20th July 2026

Littlehampton Town Council
Laura Chrysostomou
Manor House
Church Street
Littlehampton, W Sussex
BN17 5EW

Application No: LU/137/26/PL
Site Address: 1 Beach Road Littlehampton BN17 5HY
Description of works: Change the use from Class E to a mixed Class E and C3 Residential Use consisting of 4 No. commercial units at ground floor level, No. 4 residential units at first floor level, No. 2 residential units at second floor level and proposed external alterations including a first floor extension to the eastern elevation, 4 No. dormers and 2 No. roof lights (resubmission following LU/168/25/PL). This application is in CIL Zone 4 (Zero Rated) as flats.

FLAT E	87sqm
FLAT F	51sqm
FLAT G	87sqm
FLAT K	45sqm

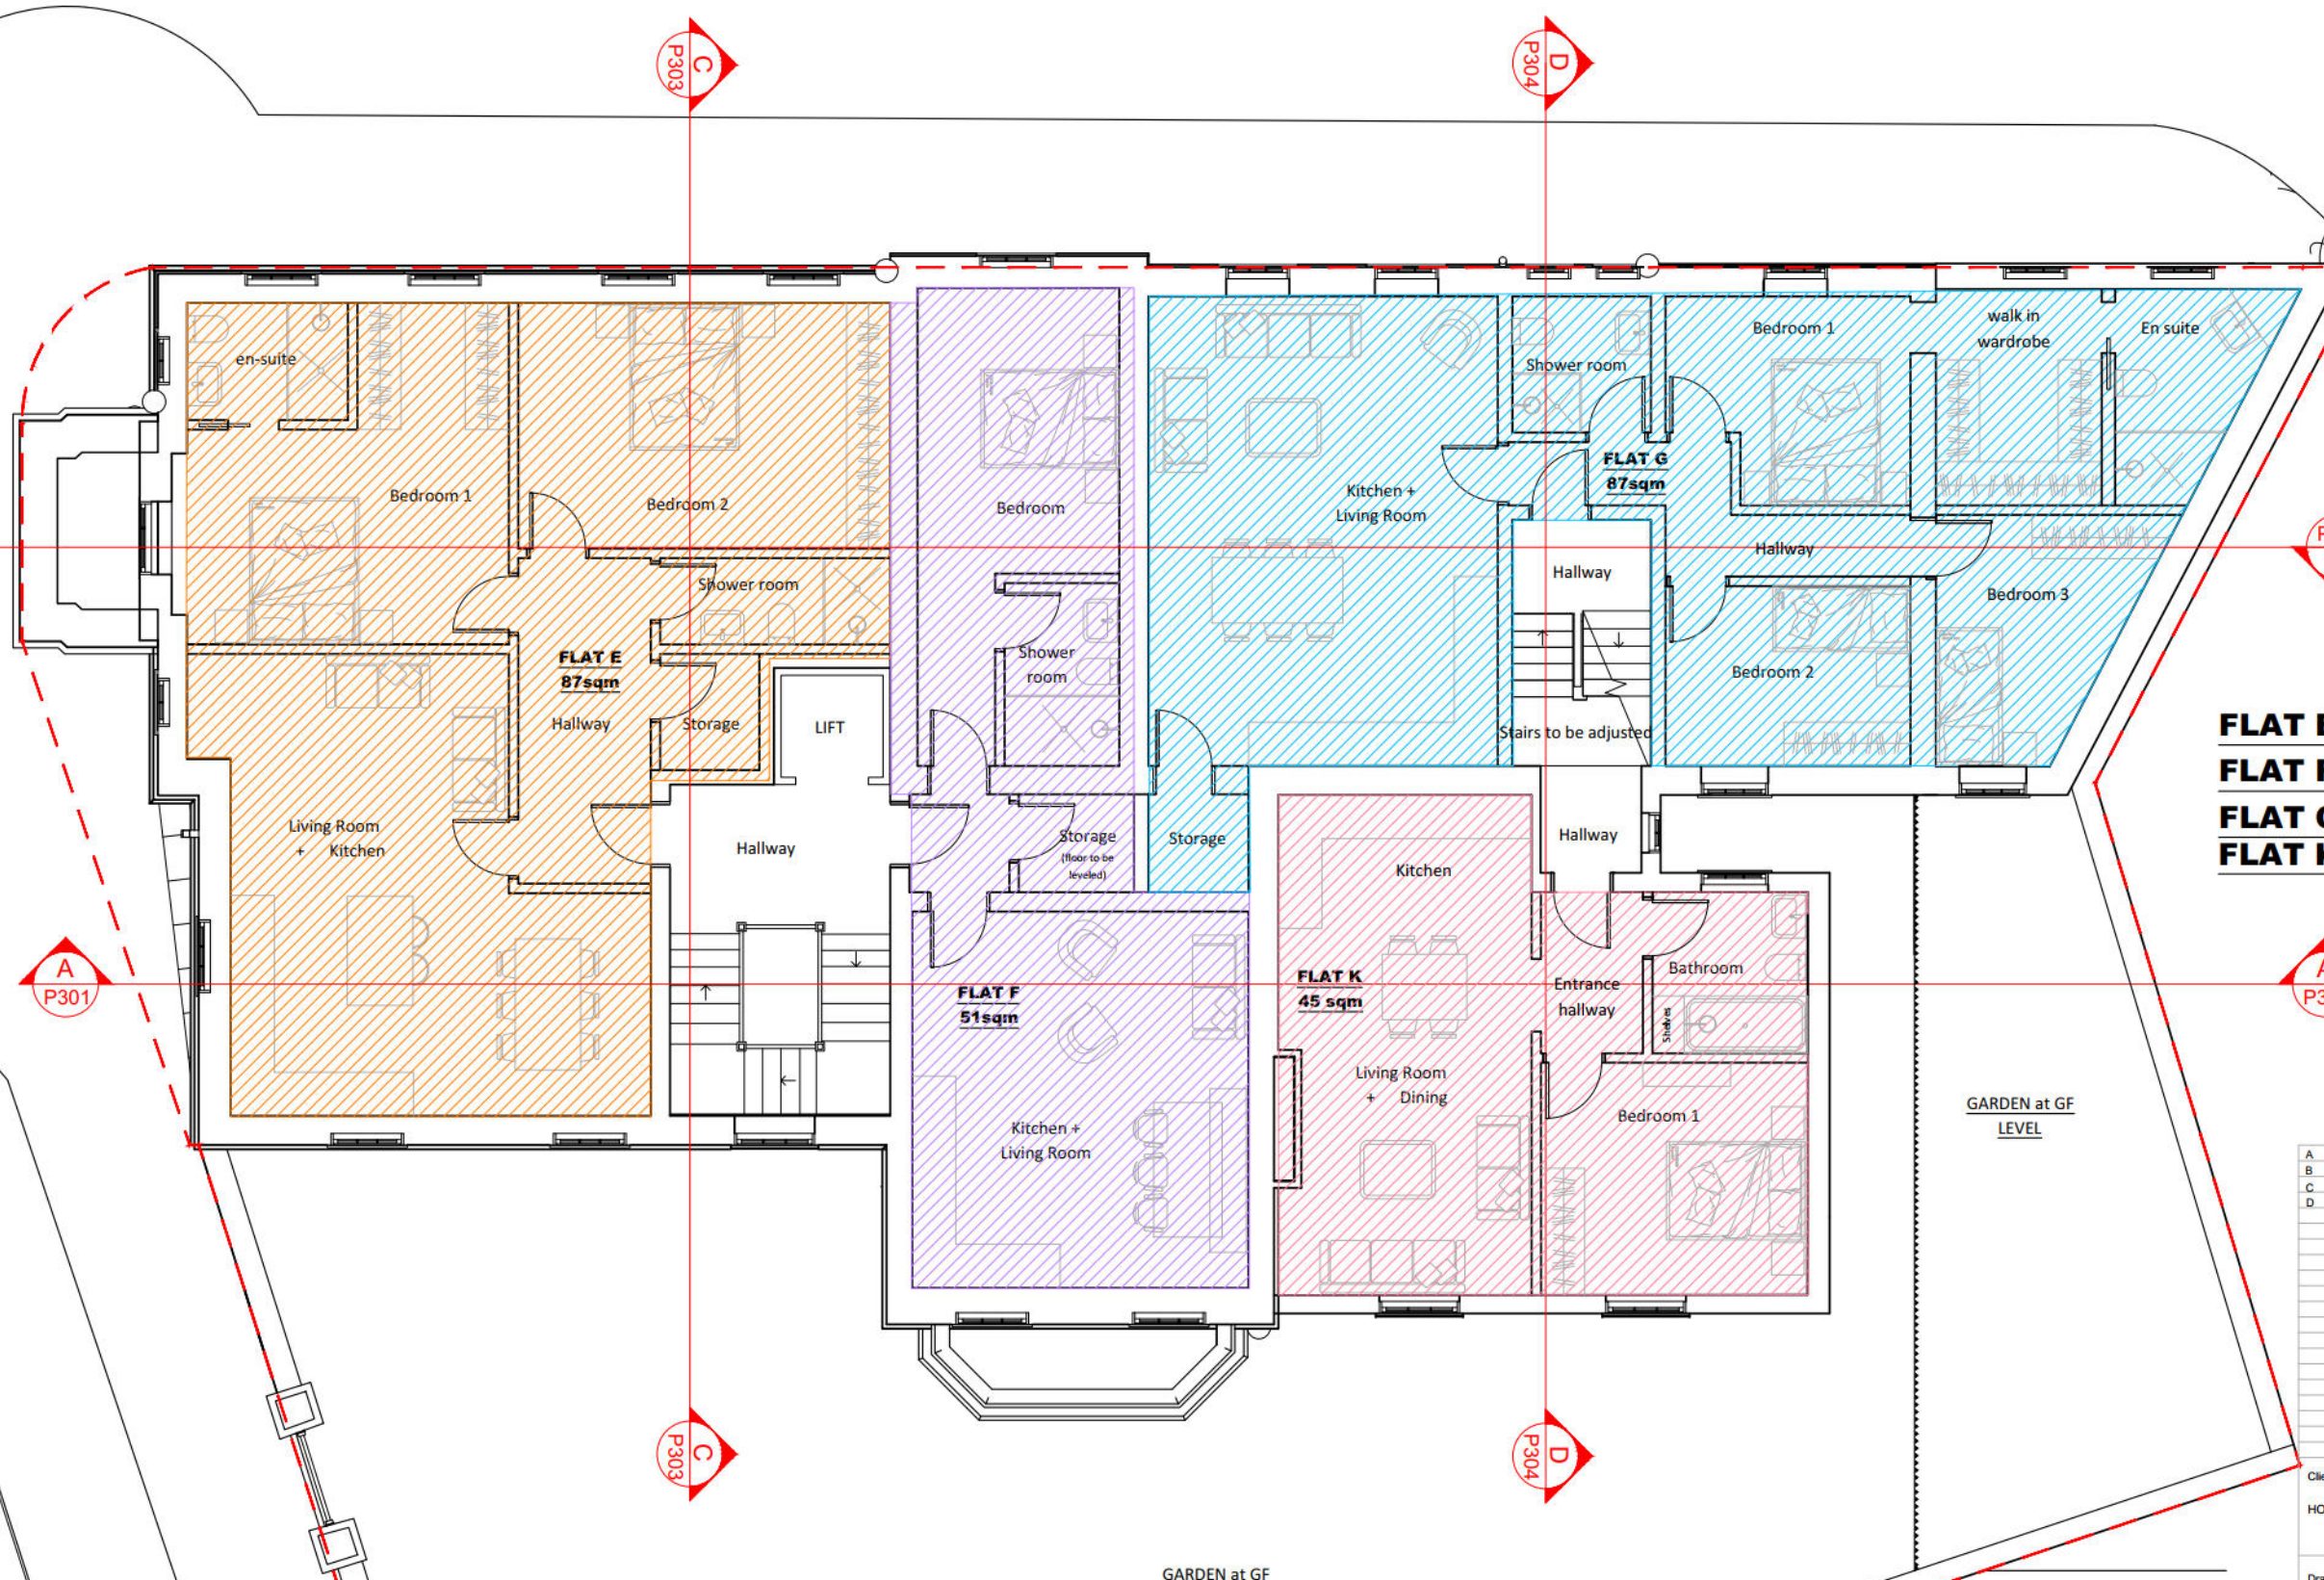
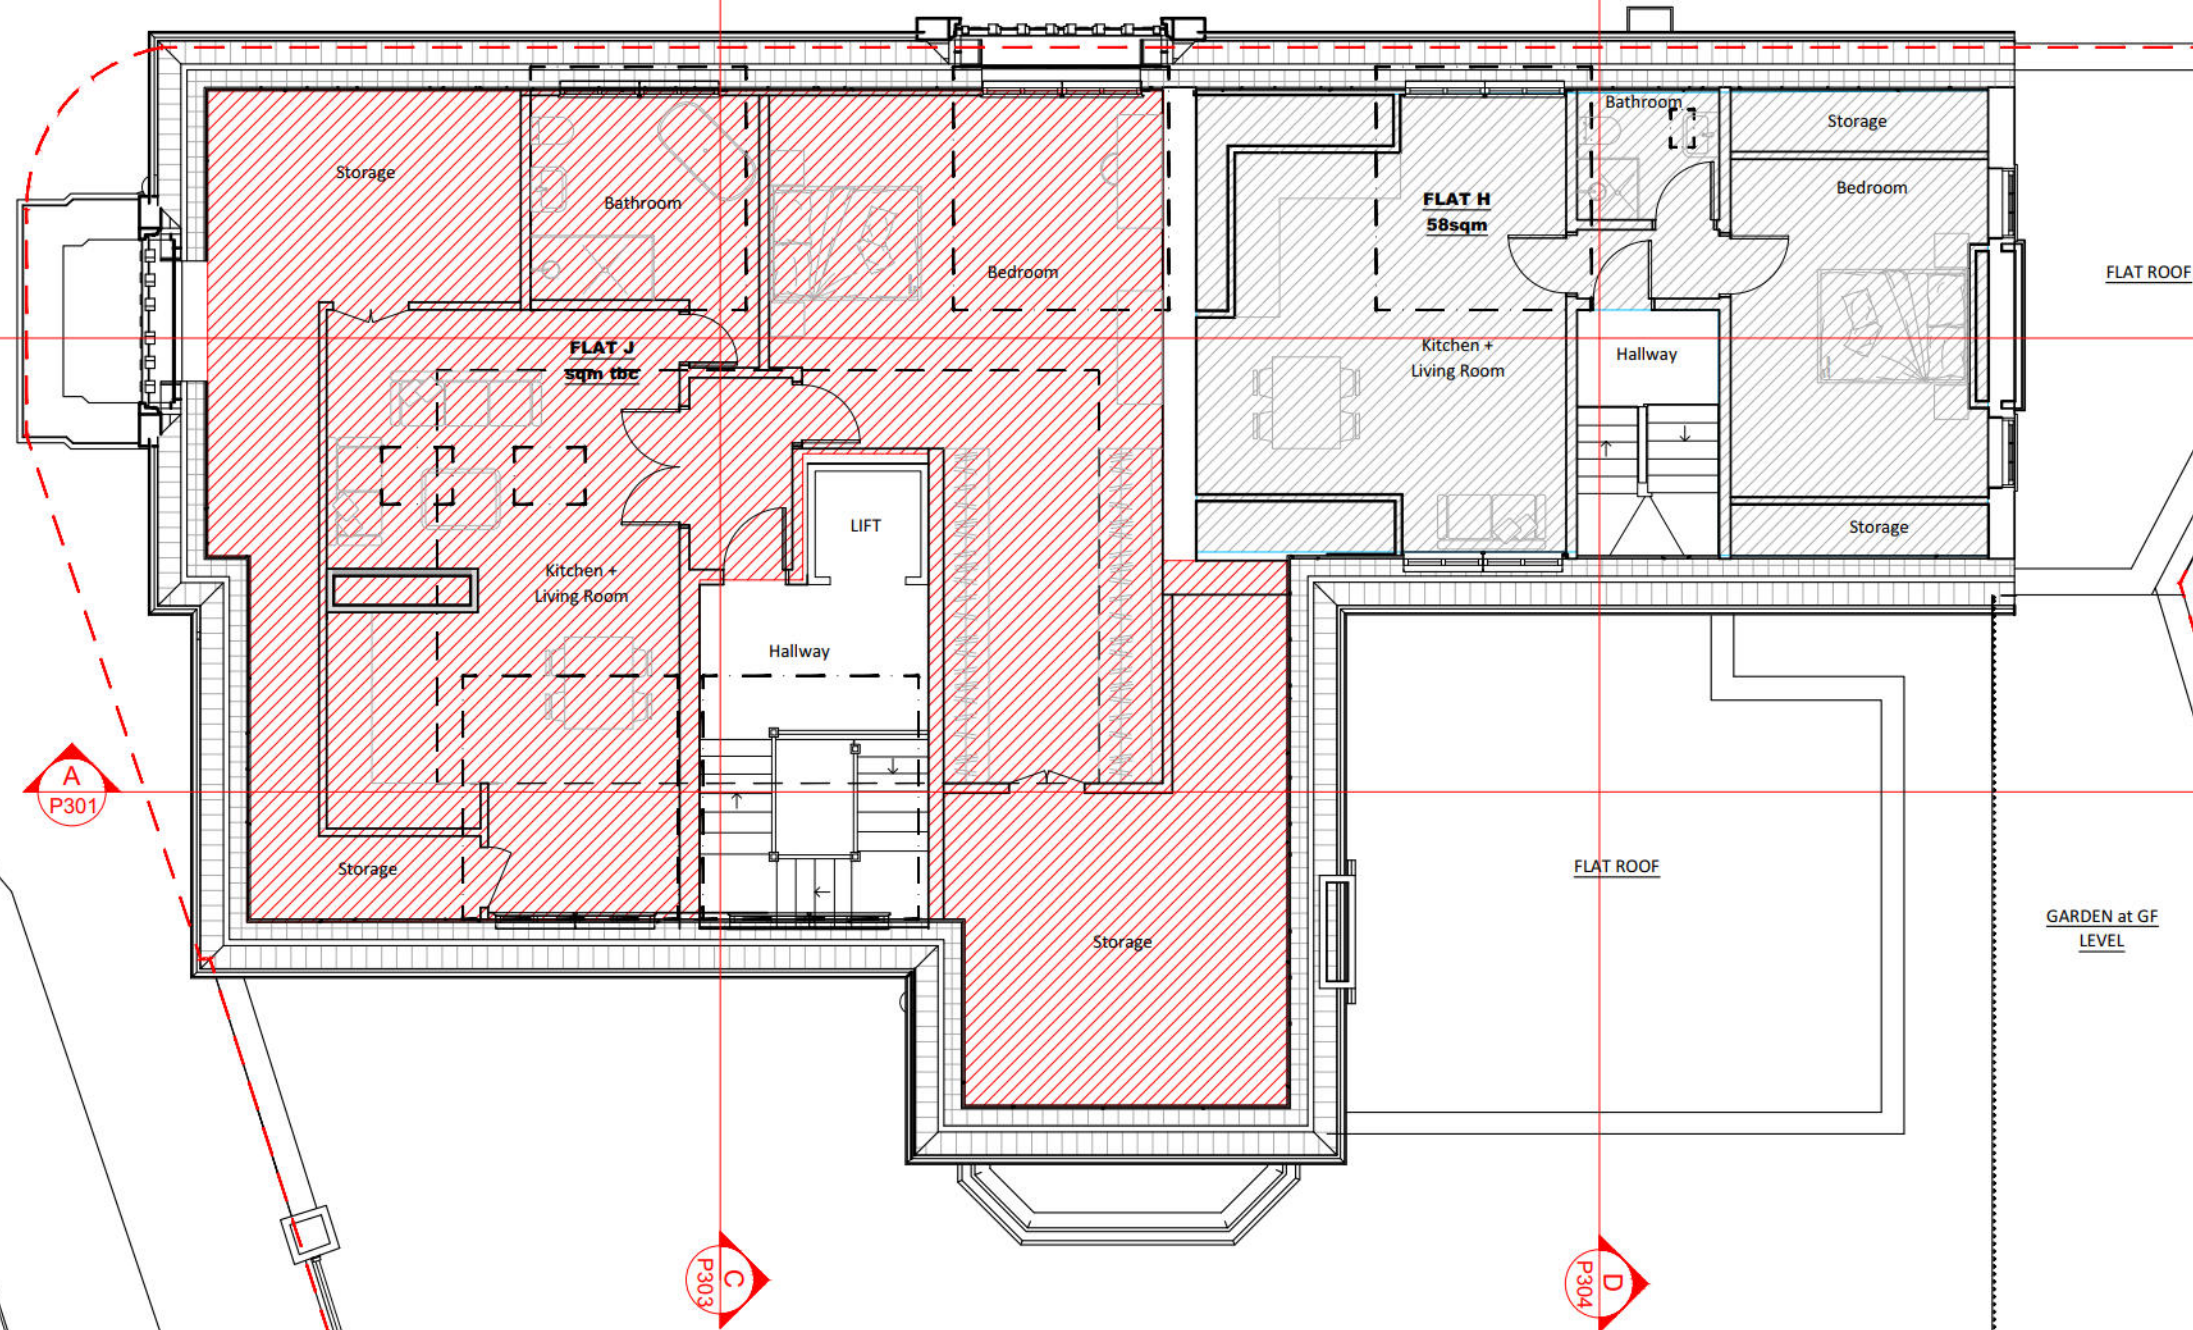
The committee objected due to the revised residential layout, specifically flat K, falling under the nationally described space standards for a 1 bedroom, 2 person dwelling. Objection for the application overall could be reconsidered once habitable size standards had been met, as seen demonstrated in the superseded plans in the previous application. Previously, support was given for the ground floor's commercial units which aligned with the aims and objectives of our Town Centre Strategy. Support for the additional commercial units was maintained by the committee.
